Your ref: TR050007  
My ref: DCO/TR050007/HinckleySRFI

7<sup>th</sup> February 2025

**TR050007 Hinckley SRFI– Warwickshire County Council (20040686/HRFI-AFP550 )  
Extension of Time - Comments on Documents Submitted by Applicant 10<sup>th</sup>  
December 2024**

Drawing file: TR050007 / TR050007-002508-Hinckley NRFI Appendix 14 - Gibbet Hill Mitigation Swept Paths.pdf

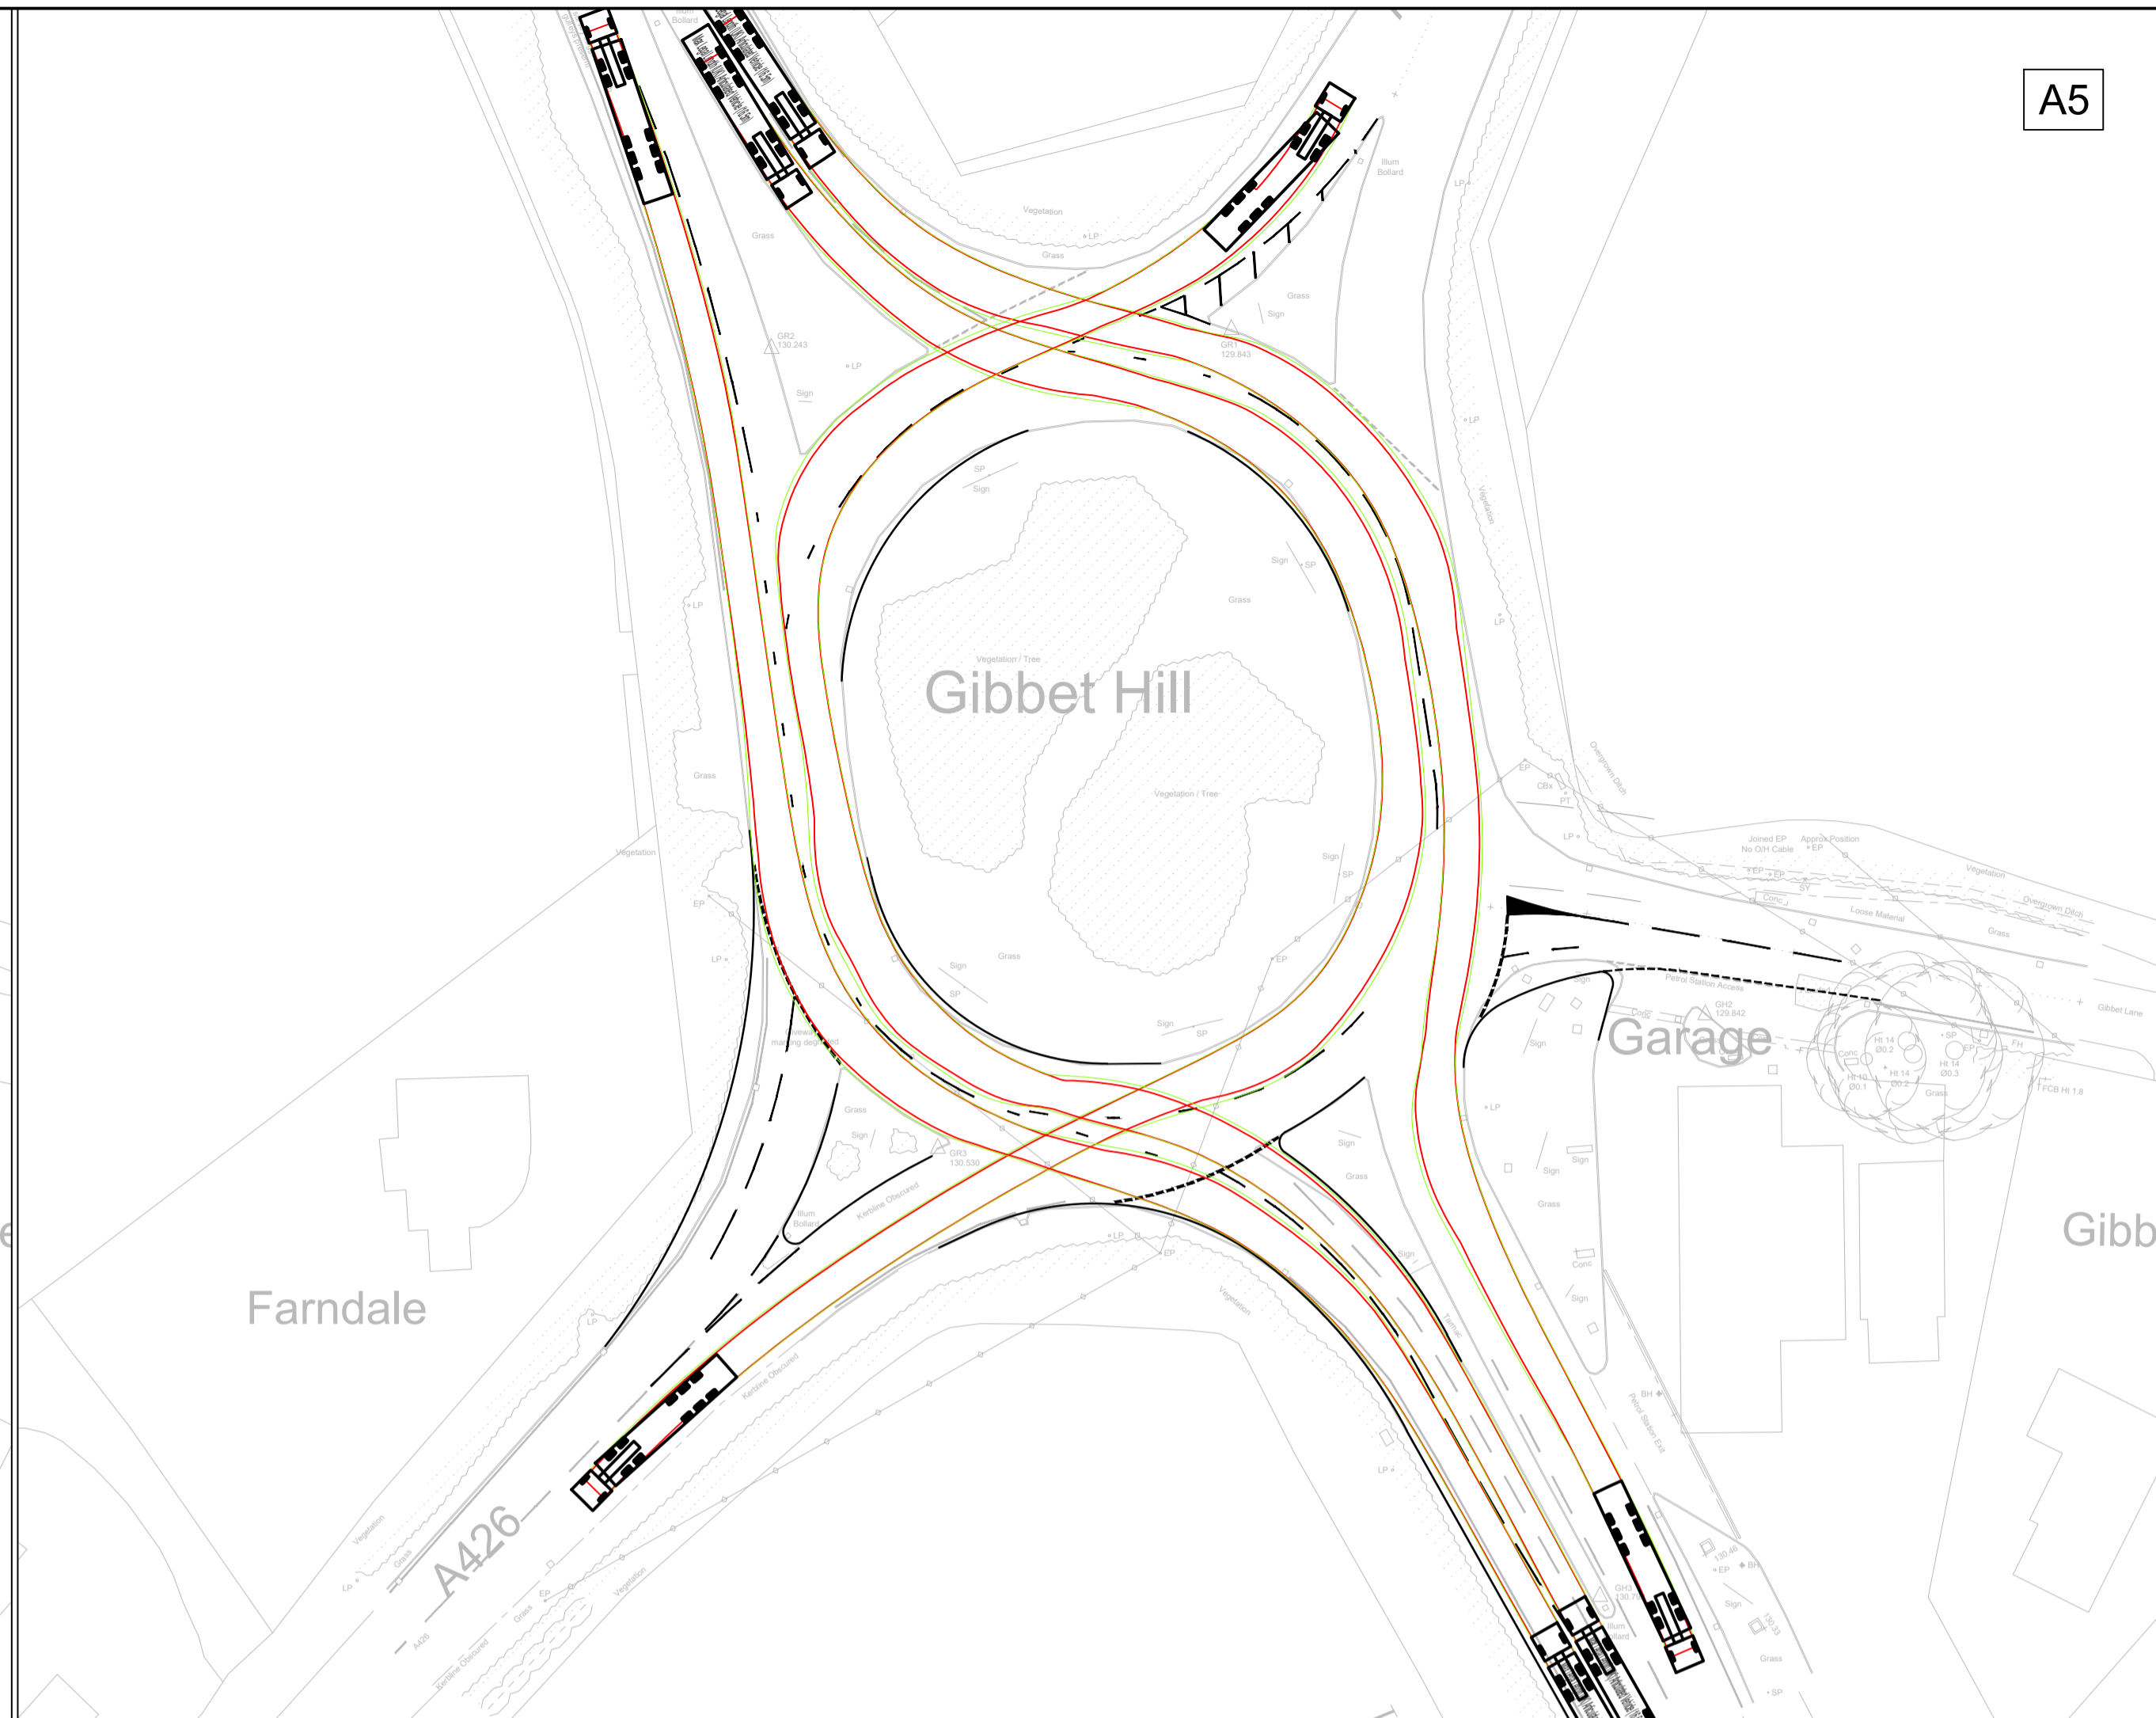
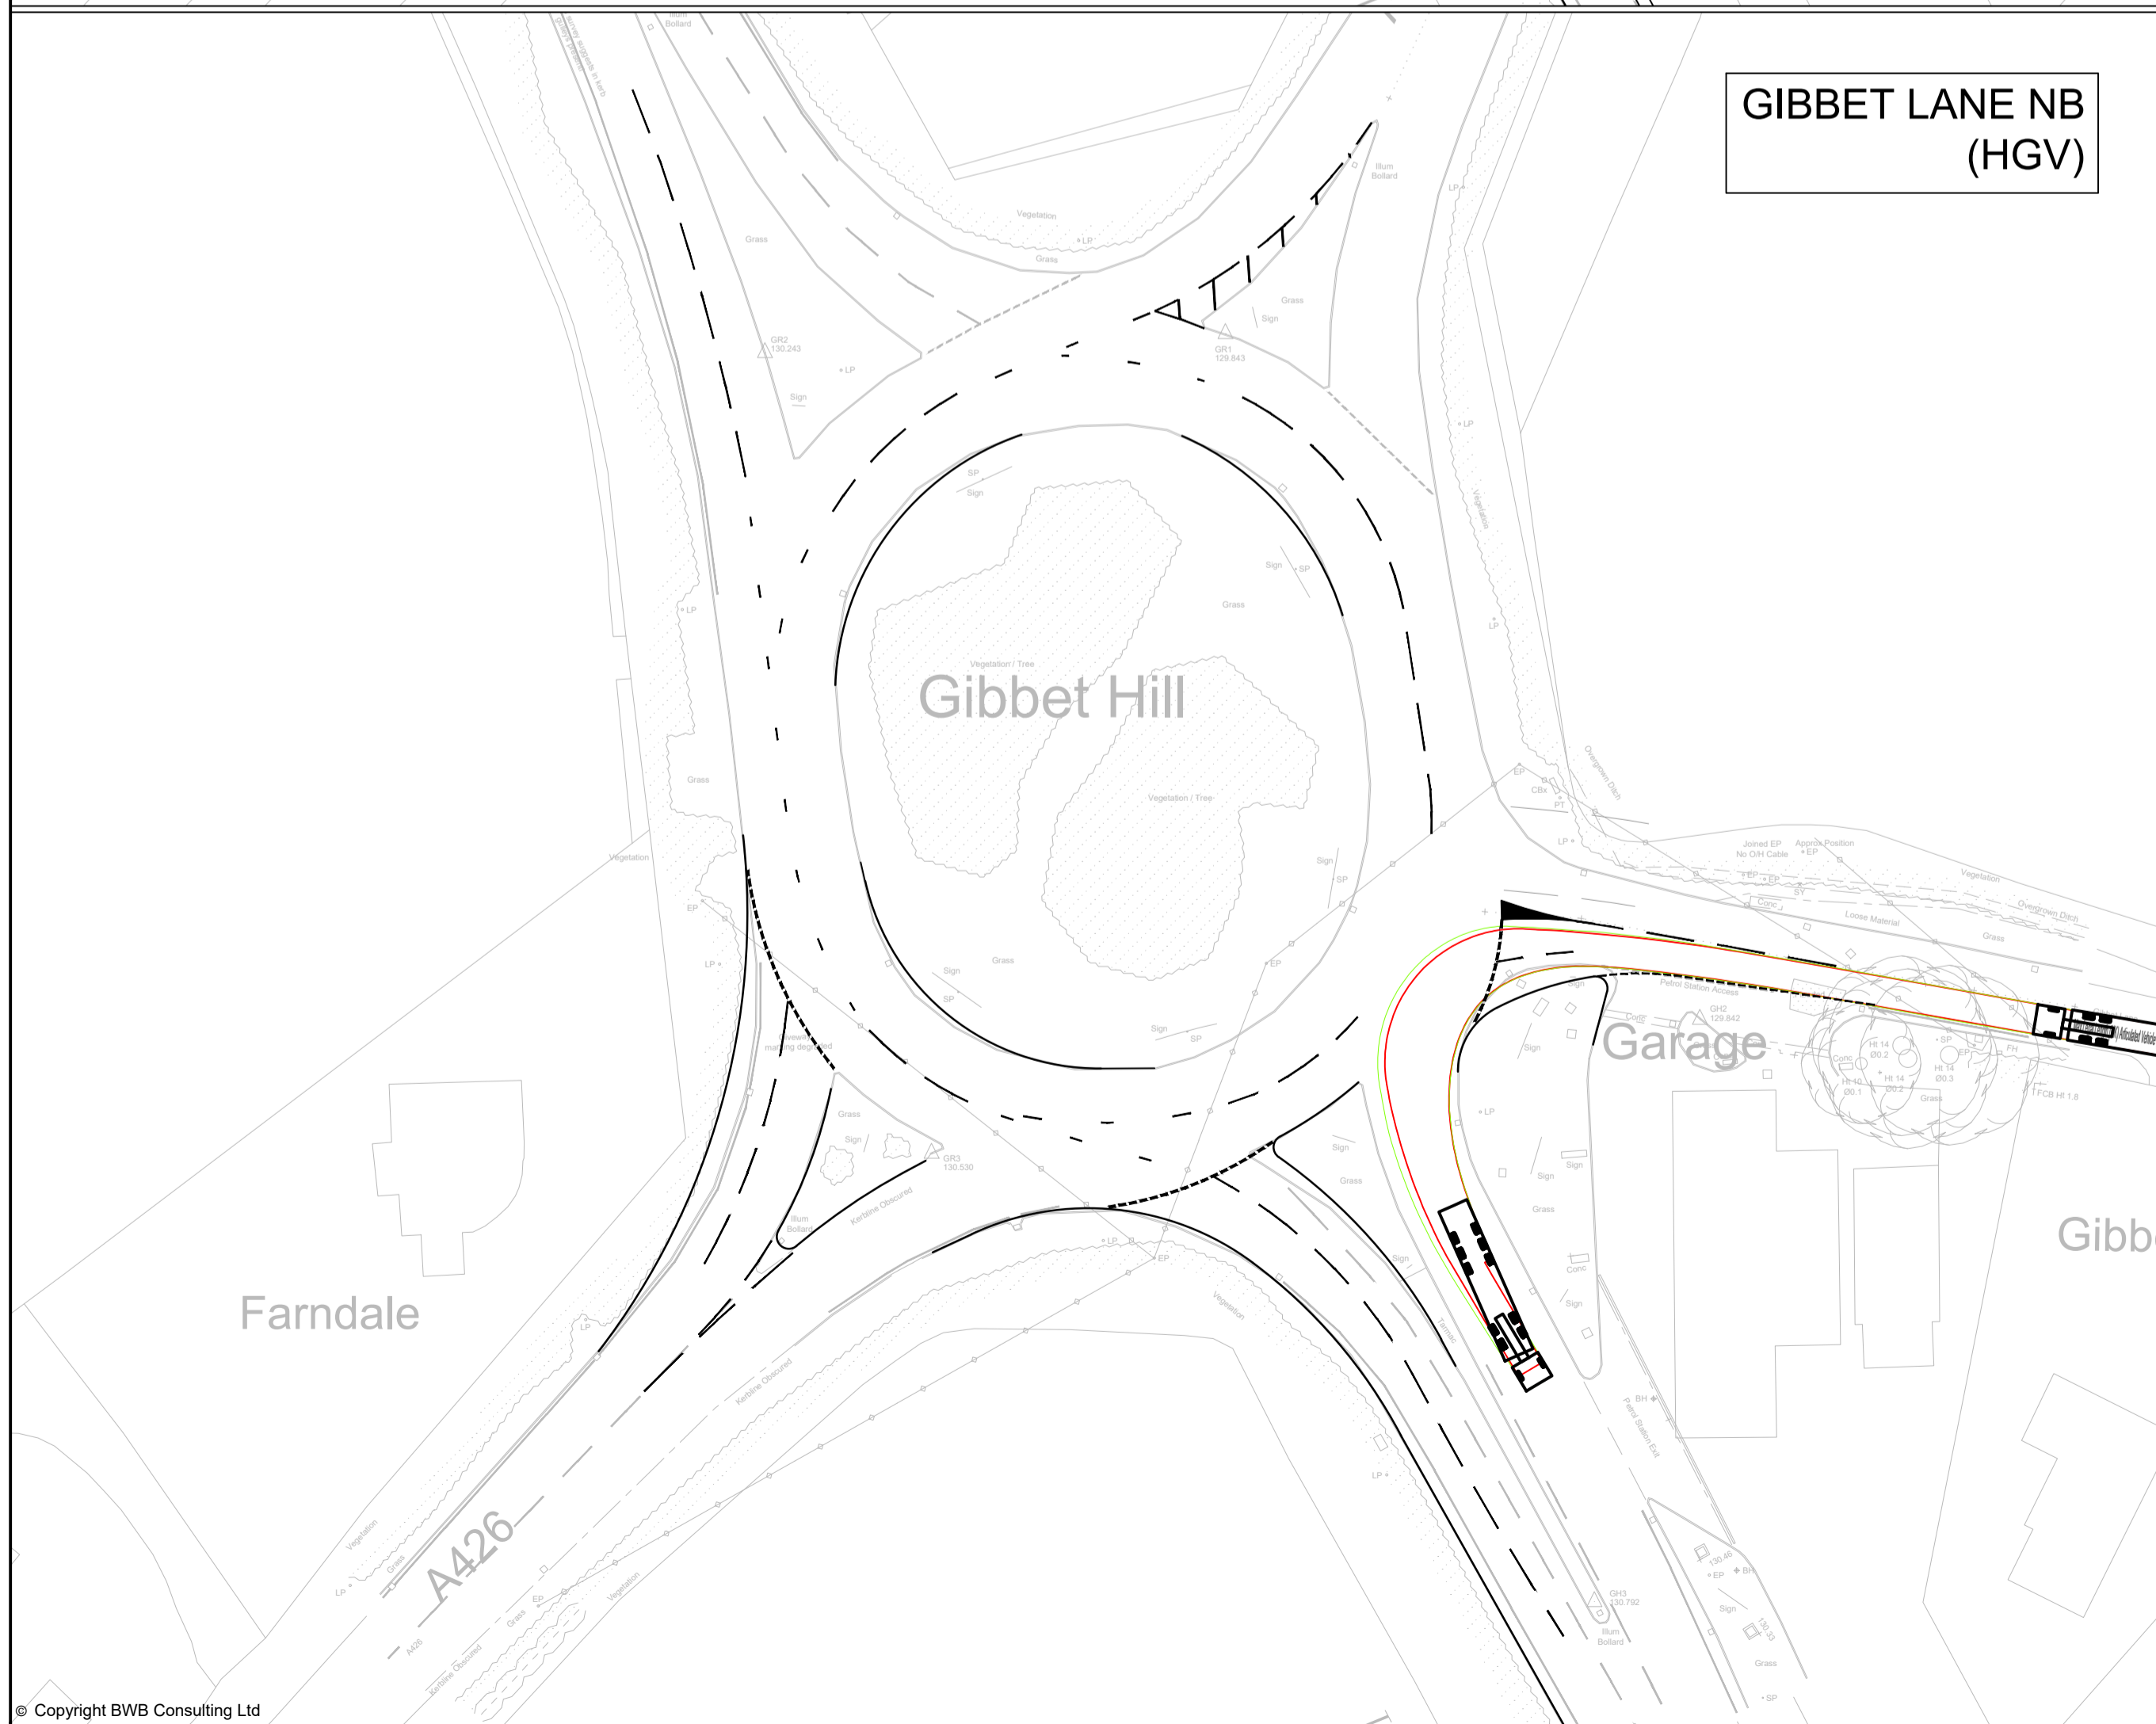
A concern raised by WCC with the proposed design is the swept path tracking. National Highways previously raised a concern over the likelihood either for two HGV's travelling side by side entering the junction and/or travelling around the circulatory carriageway for side swipe incidents to occur. If not addressed as part of the mitigation scheme WCC consider it is likely that HGV's will continue to position centrally on the approaches and on the circulatory to minimise this risk, therefore the mitigation scheme will not deliver the improvements intended. The revised scheme shows some minor kerb changes on the circulatory carriageway and some white lining on the circulatory carriageway. Whilst the swept path drawing referenced in the Road Safety Audit Brief (HRF-BWB-GEN-XX-DR-TR-134) shows the HGVs travelling side by side, the tracking speed used is 15kph (9.3mph), and some of the tracks have used a large number of target points to create the path which may indicate that a smooth and constant driving arc may not be possible in practice. BWB have advised that:

It is considered that HGVs will want to travel faster than 9mph around the circulatory of this reasonably large ICD roundabout, and if they cannot do so safely then they will continue to occupy central positions on the approach lanes and the circulatory. Notwithstanding the above assurance that the speed used is appropriate, if the DCO is consented, swept paths with speeds more commensurate with a large roundabout should be provided as part of the Road Safety Audit, as well as the tracking for semi – trailer HGV's, in order to be assured that an agreed mitigation scheme will be suitable and deliverable.

Other than the above parameters, the design speed to be used for swept path analysis is not stated in the DMRB. However, the swept path analysis was undertaken using the industry standard Autodesk Autotrack software. The software guidance recommends that manual amendments are made to limit turning radius where paths are tested faster than 15km/h due to dynamic effects on the vehicle which are not modelled by the software.

The guidance warns against testing above 15kph as adjustments should then be made to the dynamic effects (weight shift, tyre grip, roll over effect and a number of variables per vehicle). The guidance then goes onto warn: "The pre-defined dynamic values used in these dynamic settings are taken from AASHTO and TAC handbooks are intended for use with normal road vehicles, i.e. cars, lorries etc. If your vehicle is very large, e.g an aircraft or very small then they may not be appropriate, or you may need to define custom values".

Vehicle tracking is a constant speed analysis whereas in reality, vehicles will slow down at the entry to the roundabout and then speed up again at the exit. Adjusting the speed variable only effects the steering input applied over a certain distance as steering is applied at a fixed, constant rate. Therefore, at higher speeds, vehicles travel further while steering angle is being applied. The vehicle speed setting does not affect the amount of space required for a vehicle to undertake a given manoeuvre.

Therefore, the speed used in the swept path analysis is appropriate and altering this speed would have negligible effect on the design.
